**WEST SUSSEX COUNTY COUNCIL
PLANNING SERVICES CONSULTATION**

SUBJECT: LU/17/197 - Change of use of existing leisure use of upper ground floor to form 3 No. flats, extension of first floor to form 2 No. flats & creation of 1 No. flat in roof space (resubmission following LU/395/14/PL & LU/84/16/PL).

90 & 91, South Terrace, Littlehampton, West Sussex, BN17 5LJ

1:500 SITE + LOCATION PLAN.

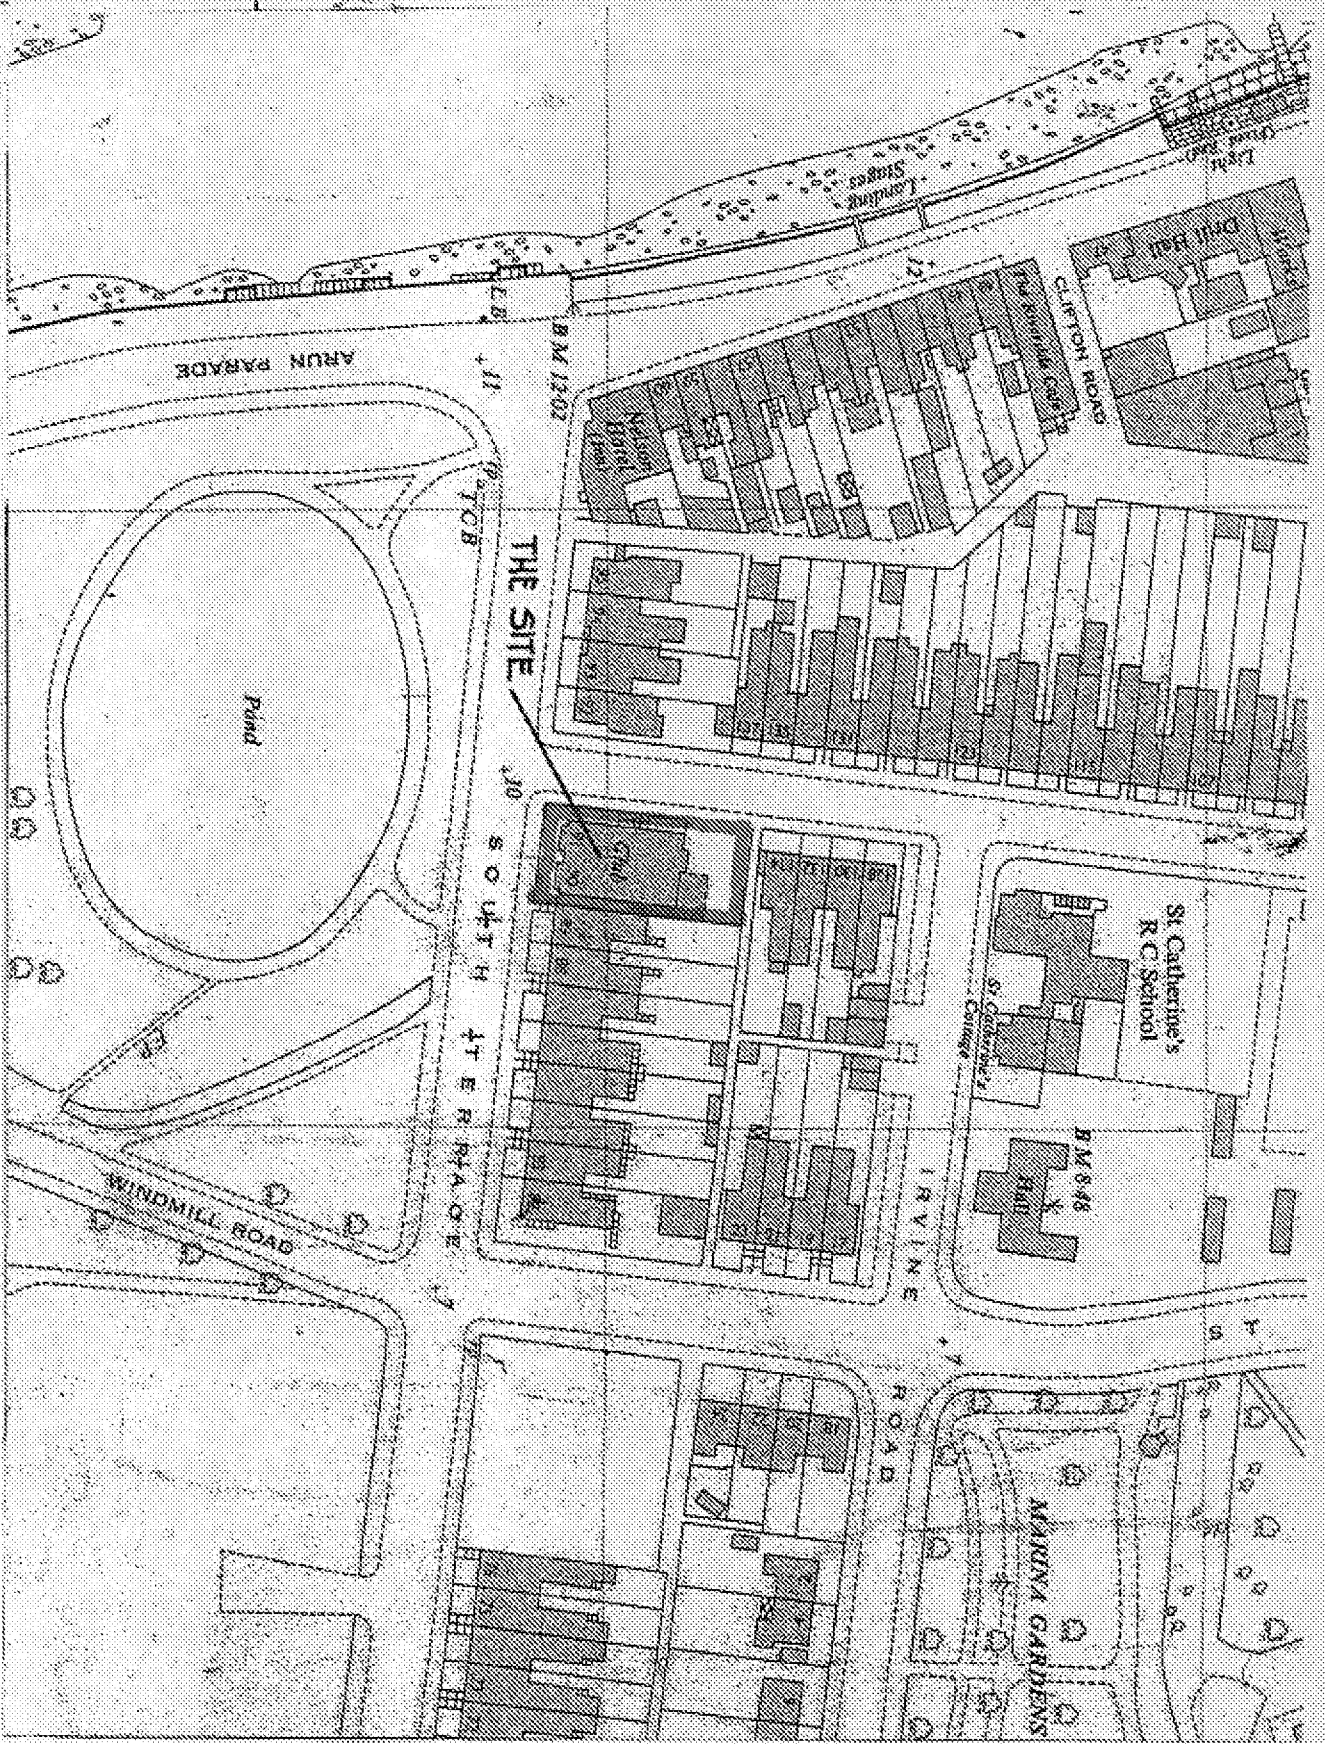
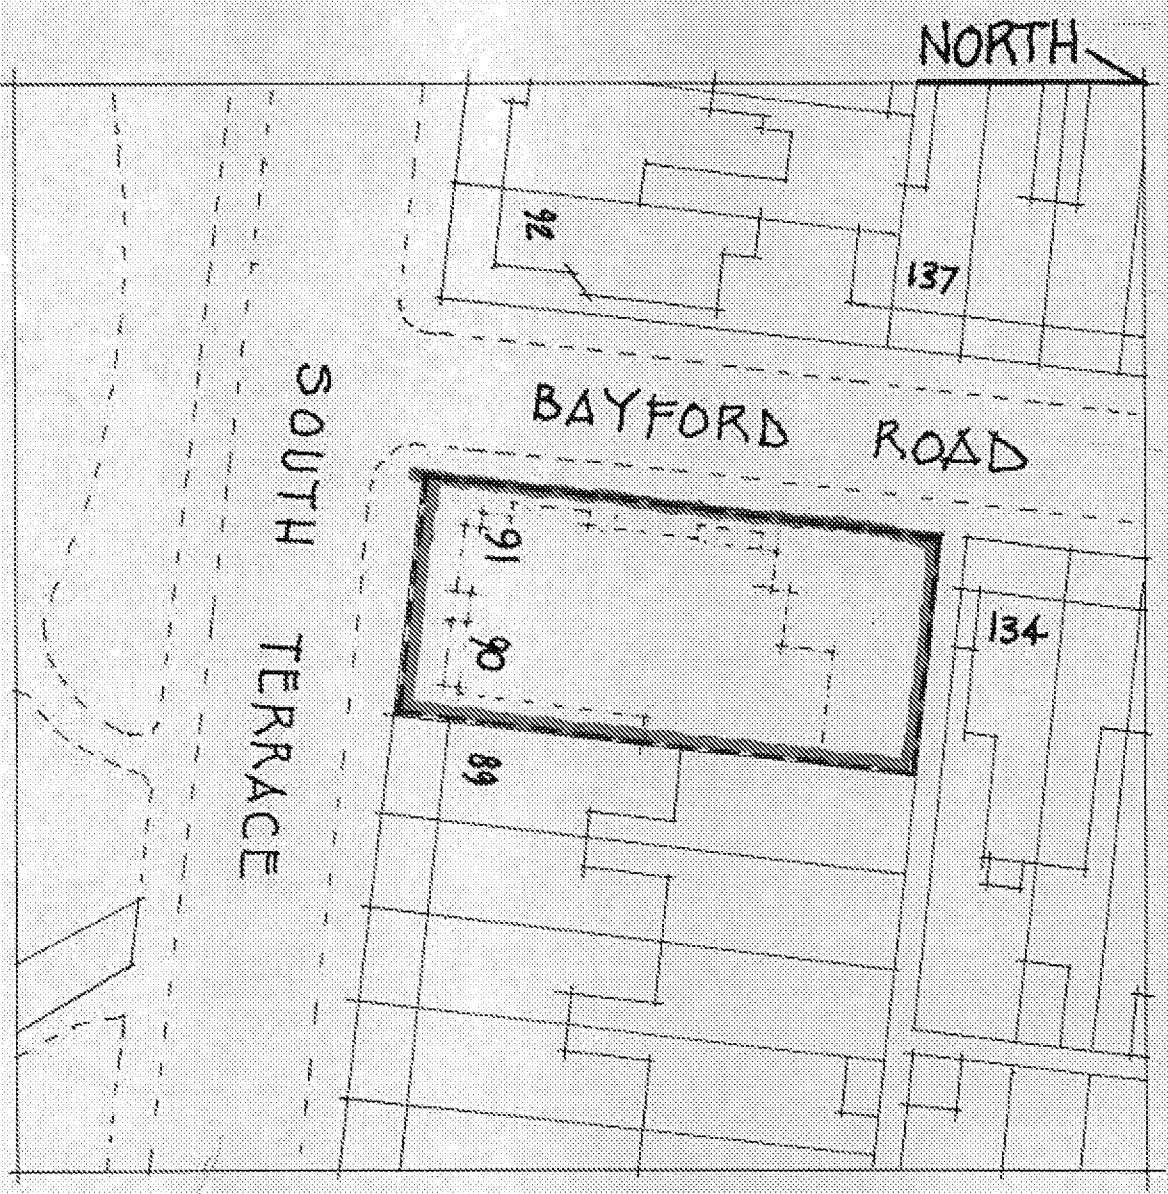
A total of 4 car parking spaces will be provided to serve the 6 flats, presumably on an unallocated basis. It would be anticipated that a development of this size in this location would attract the demand for 6 car parking spaces on an unallocated basis. While there is a shortfall of 2 spaces the existing use of the site must be taken into consideration. The existing D2 use would have attracted a significant quantity of parking demand (1 space per 22sqm); taking into consideration the loss of D2 use class the overall parking demand of the proposed would be considered lower than the existing use of the site. Nevertheless the LPA may wish to consider implications towards on street car parking amenity towards other residents of South Terrace and Bayford Road.

No part of the development shall be first occupied until the car parking has been constructed in accordance with the approved site plan. These spaces shall thereafter be retained at all times for their designated purpose.
